Re: Falcon Marketplace Final Plat (SF-19-001 CDR-16-007)

Please accept this response letter to your comments dated June 11, 2019

We trust you find our responses to the 3rd review of the Falcon Marketplace Final Plat acceptable. We look forward to working with the County in processing the submittal. Please call if you have any questions or require any additional information.

**C1.13**

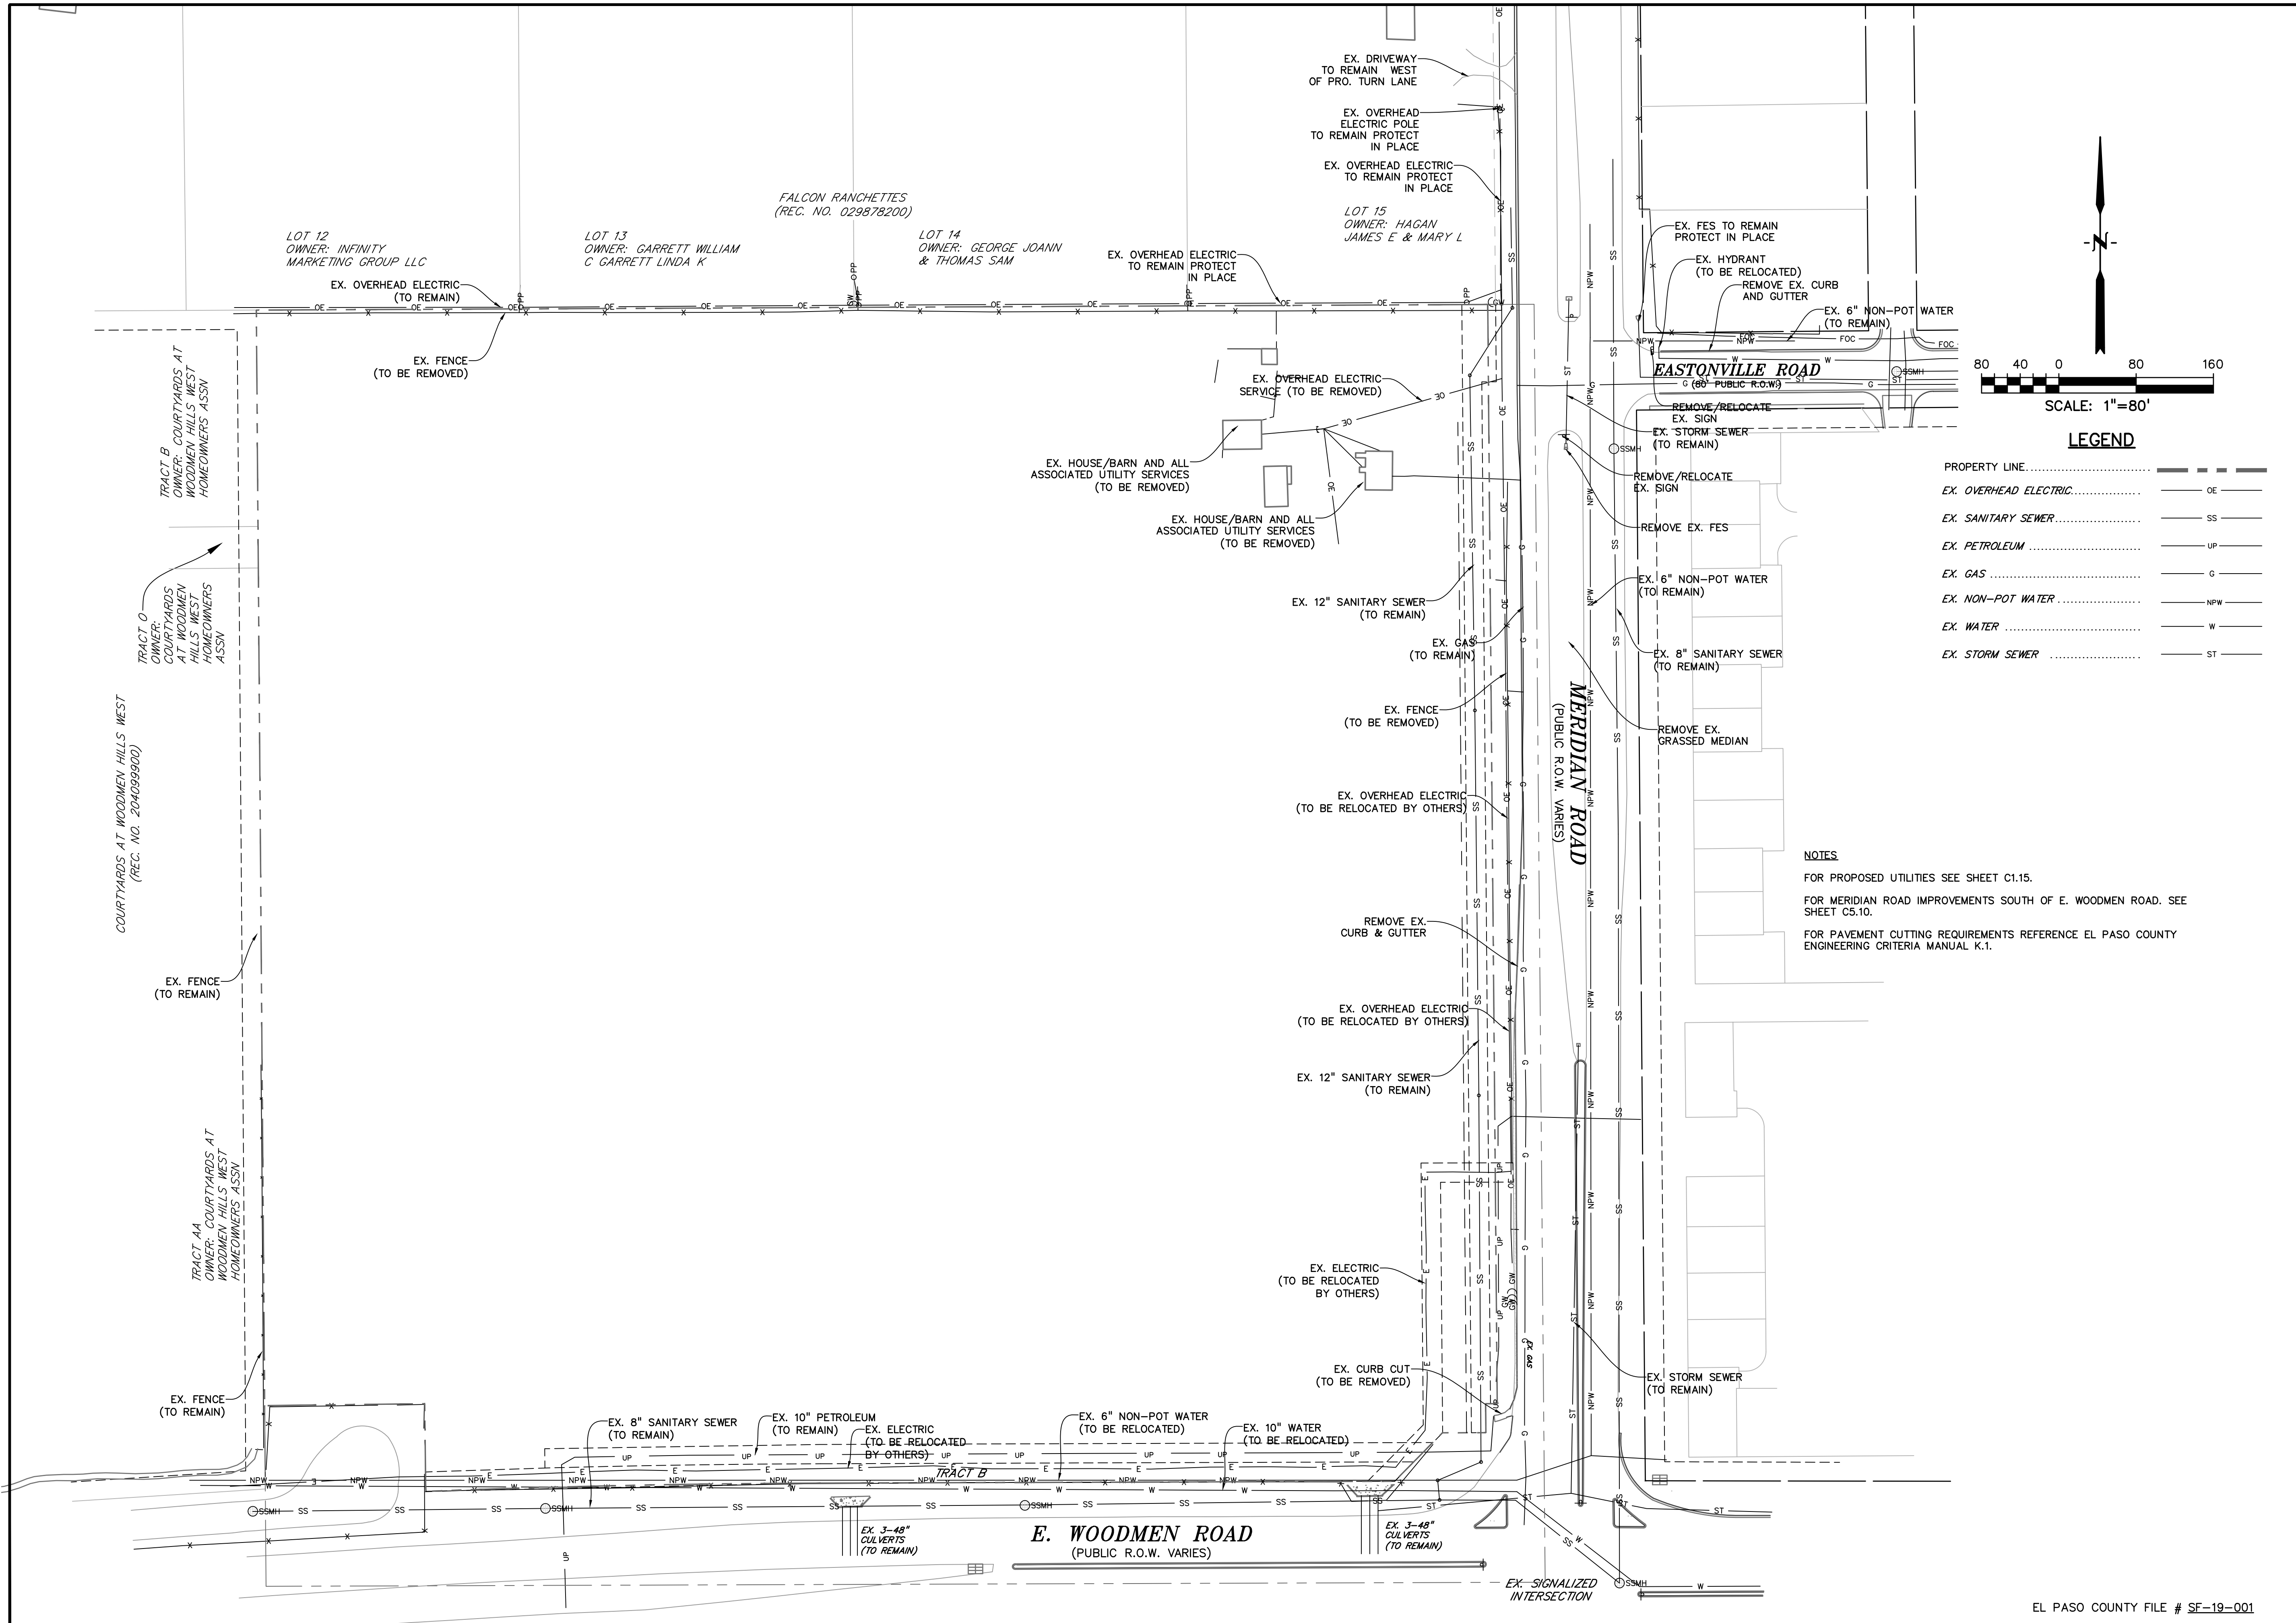
Subject: Callout
Page Index: 4
Date: 6/6/2019 2:48:44 PM
Author: dsdrice
Color: ■
Layer:
Space:
Page Label: [4] 4 C1.13

Dimension height

Subject: Cloud+
Page Index: 4
Date: 6/6/2019 2:49:15 PM
Author: dsdrice
Color: ■
Layer:
Space:
Page Label: [4] 4 C1.13

this doesn't look right

Dimension revised

Dimension revised

DEMO & UTILITY  
RELOCATION  
PLAN

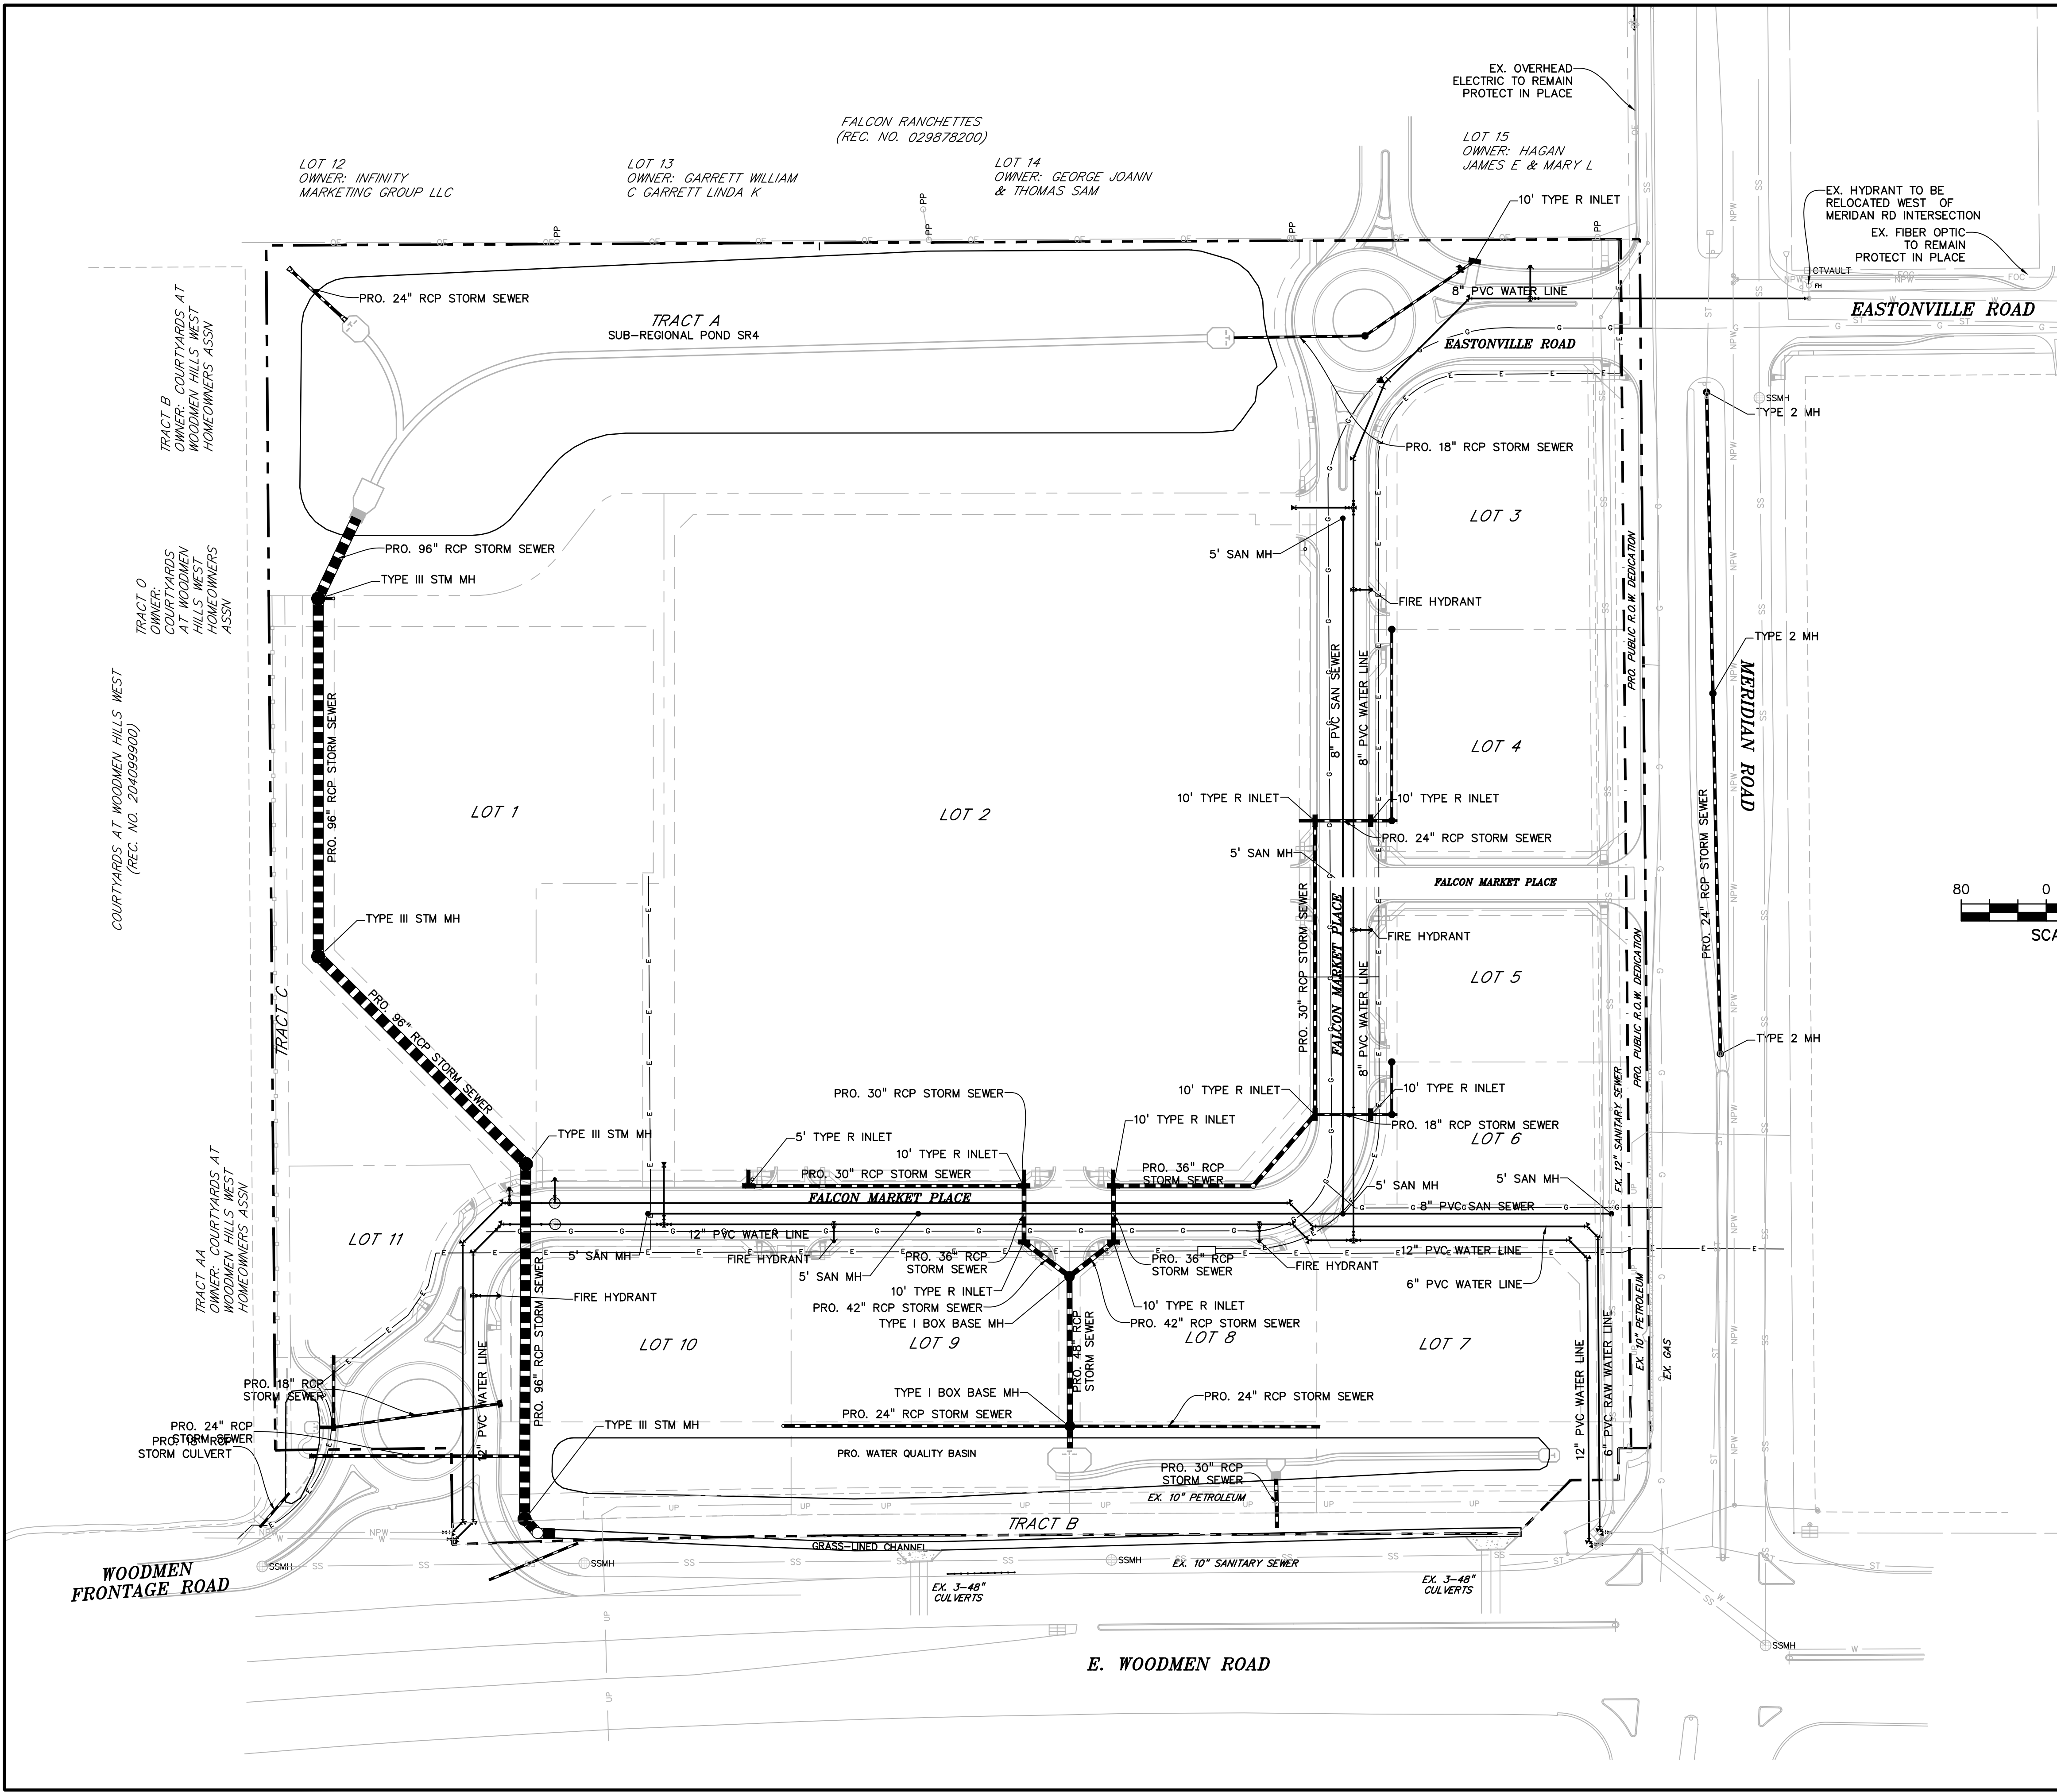
13. **Sheet C1.14 does not show proposed utility locations; add these to this sheet or provide a separate utility plan showing all existing and proposed/relocated utilities. Show all utilities on the GEC plan and plan and profile sheets. Separate utility plan added to set.**

Subject: Callout
Page Index: 5
Date: 6/10/2019 11:06:13 AM
Author: dsdrice
Color: ■
Layer:
Space:
Page Label: [5] 5 C1.14

remove curb and gutter

Subject: Cloud+
Page Index: 5
Date: 6/10/2019 12:36:29 PM
Author: dsdrice
Color: ■
Layer:
Space:
Page Label: [5] 5 C1.14

Show where this is being relocated to on the other sheets.

Subject: Callout
Page Index: 5
Date: 6/6/2019 2:54:35 PM
Author: dsdrice
Color: ■
Layer:
Space:
Page Label: [5] 5 C1.14

Remove(?)

Subject: Cloud+
Page Index: 5
Date: 6/9/2019 10:02:55 AM
Author: dsdrice
Color: ■
Layer:
Space:
Page Label: [5] 5 C1.14

FES/culvert?

Subject: Callout
Page Index: 5
Date: 6/9/2019 10:03:00 AM
Author: dsdrice
Color: ■
Layer:
Space:
Page Label: [5] 5 C1.14

Hydrant?

Subject: Callout
Page Index: 5
Date: 6/9/2019 9:59:18 AM
Author: dsdrice
Color: ■
Layer:
Space:
Page Label: [5] 5 C1.14

Label relocation, protection, etc. for each utility

Note added

Additional "Proposed Utilities" sheet
C1.15 added to plan set.

Note added

Note revised

Note revised

Labels updated
